EL PASO COUNTY

DEPARTMENT OF PARKS AND COMMUNITY SERVICES

Subject: Mayberry Filing No.4 - (SF2317)

The Parks and Community Services Department has reviewed Mayberry Filing No.4 Final Plat and is submitting the following preliminary comments on behalf of El Paso County Parks. This application will be presented to the Park Advisory Board on July 12, 2023 and its recommendation will be provided after the meeting.

Final Plat of
MAYBERRY, COLORADO SPRINGS FILING NO. 4
 Being a replat of Tract A, MAYBERRY, COLORADO SPRINGS FILING NO. 3
 Lying the Northeast Quarter of Section 14, Township 14 South, Range 63 West of the 6th Principal Meridian
 County of El Paso (Unincorporated), State of Colorado

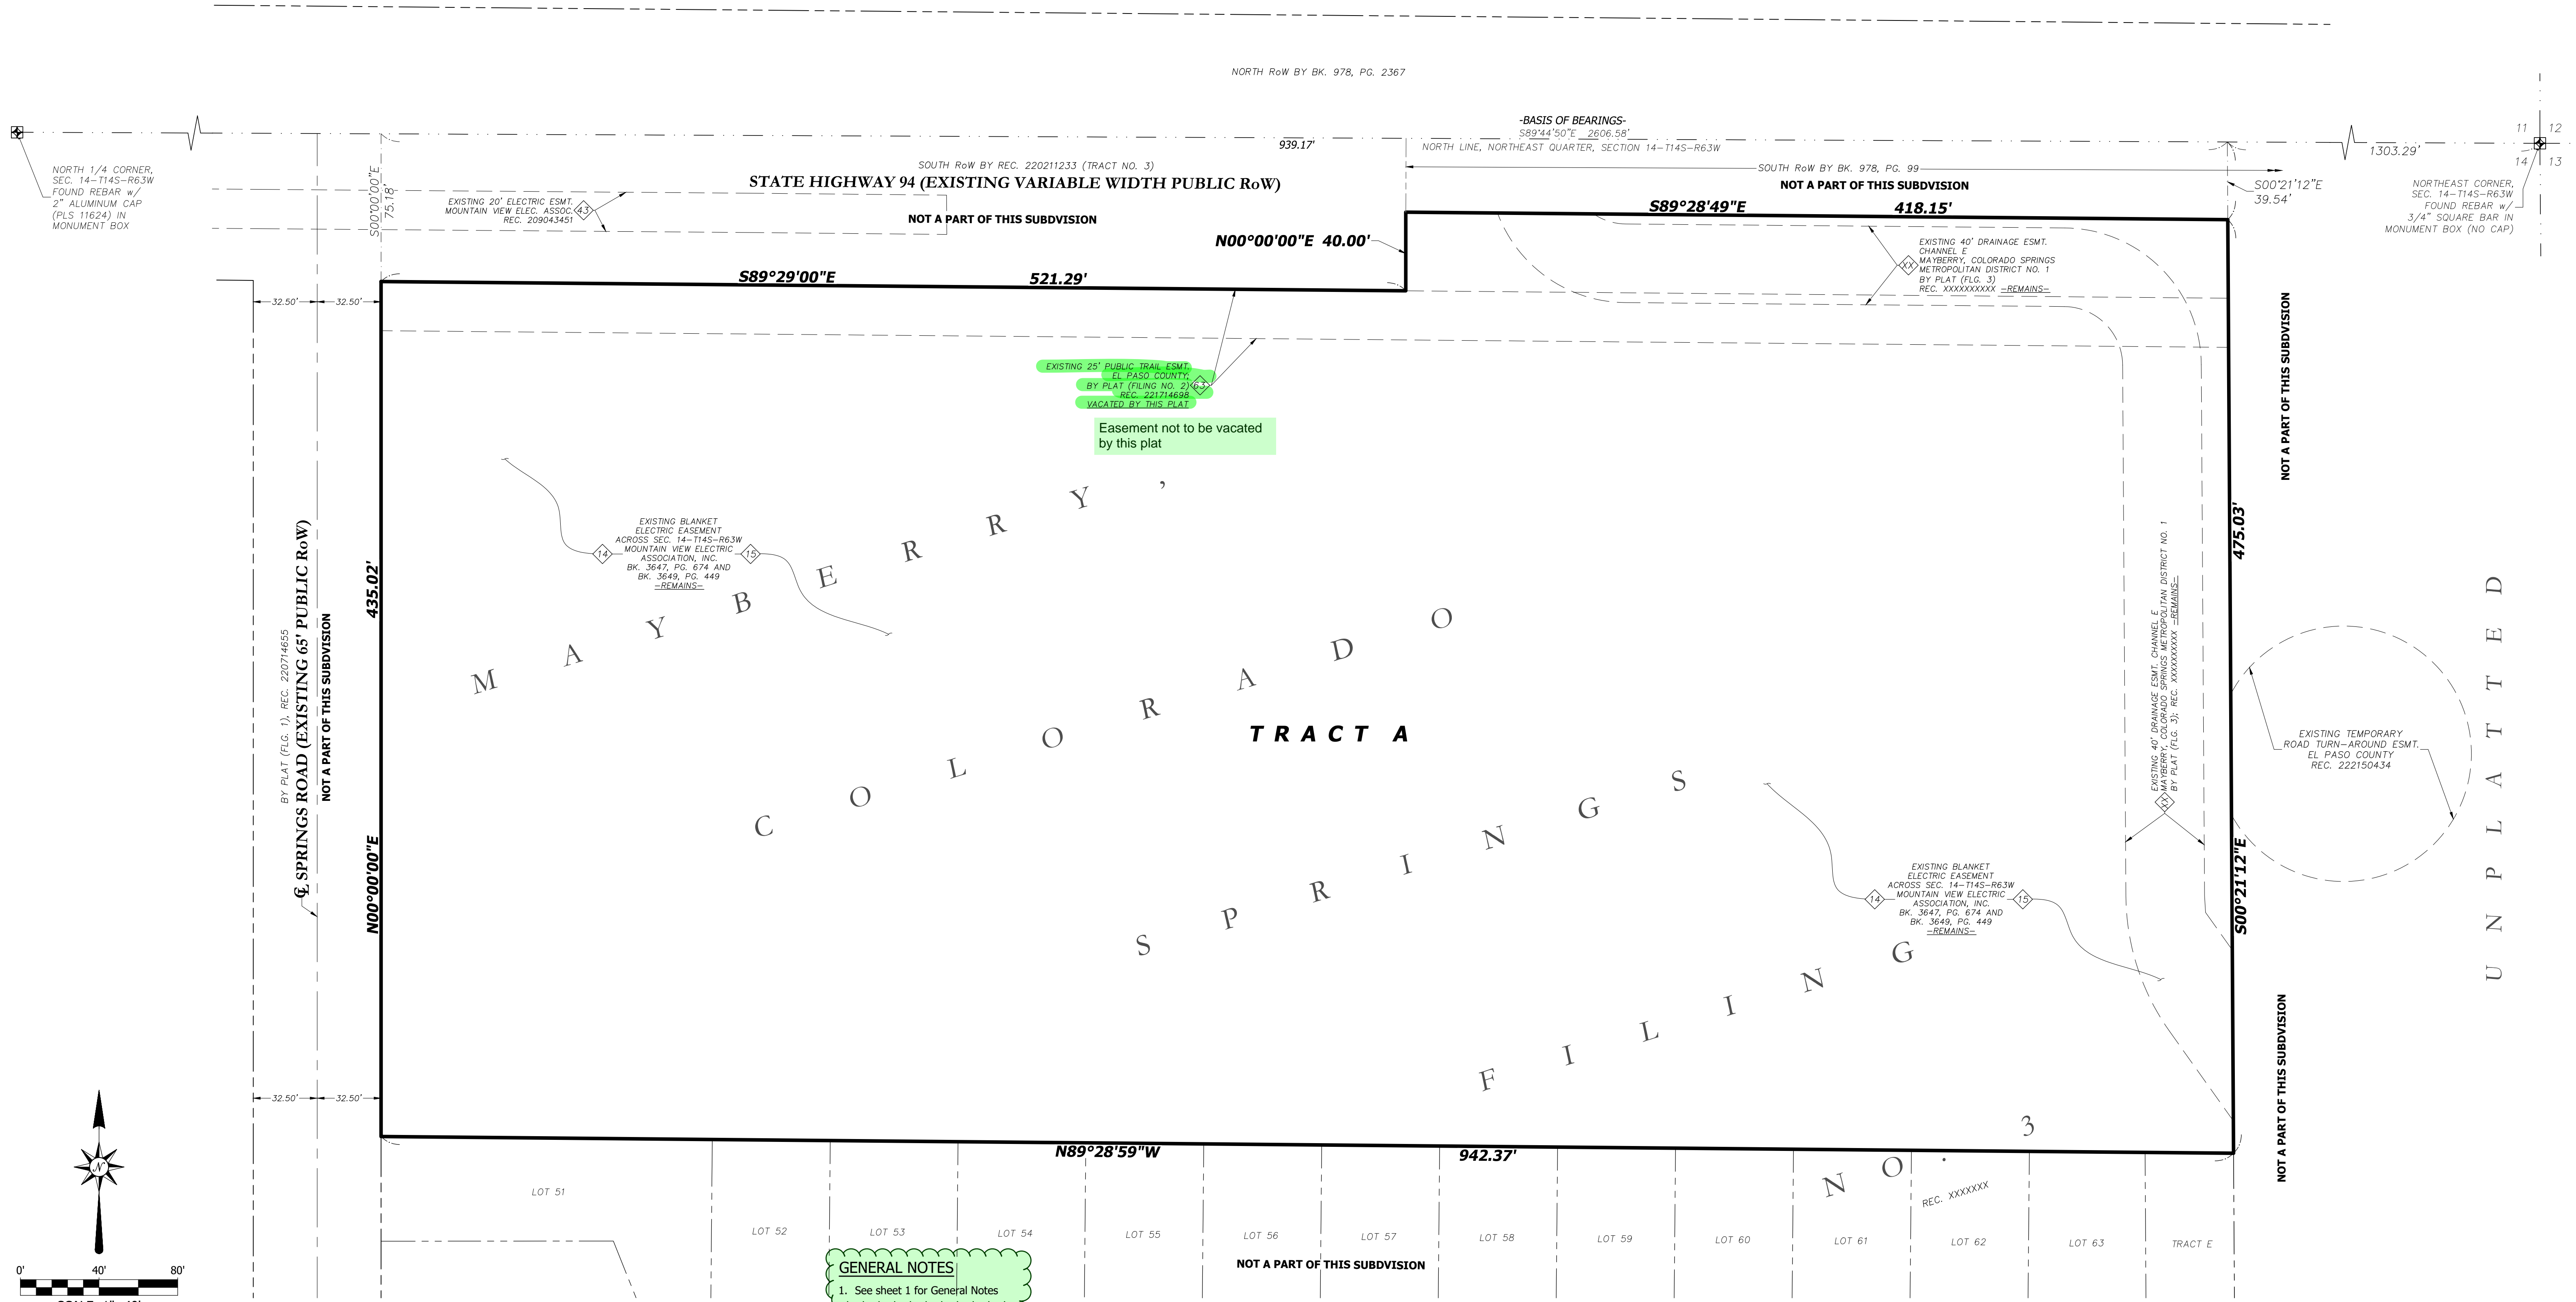
County Parks requests trail easements where development projects impact proposed County trails. As it pertains to this application, the County requests that the landowner provide a 25-foot public trail easement along the south side of Highway 94 that allows for the construction and maintenance by El Paso County of a Secondary Regional Trail, and this easement shall be shown and dedicated to El Paso County on the Final Plat. The trail easement is shown on the Filing No.4 Final Plat as "Existing 25' Trail Easement El Paso County by Plat (Filing No.2) REC. 221714698 VACATED BY THIS PLAT." The trail easement is required by the El Paso County Land Development code and shall be noted as "REMAINS" vs. "VACATED." County Parks has previously identified this error and made similar comments when reviewing Filing No. 3 in 2021 and 2022. County Parks does not have any documentation to support the vacation of the trail easement, nor has the applicant provided any justification in the application to forgo the trail easement.

Secondary Regional Trail, and this easement shall be shown and dedicated to El Paso County on the Final Plat. (2) correct the final plat note that incorrectly states vacation of the required trail easement.

Recommend that the Planning Commission and the Board of County Commissioners include the following conditions when considering and/or approving the Mayberry Filing No.4 Final Plat: (1) provide a 25-foot public trail easement along the south side of Highway 94 outside of the public right-of-way that allows for the construction and maintenance by El Paso County of a
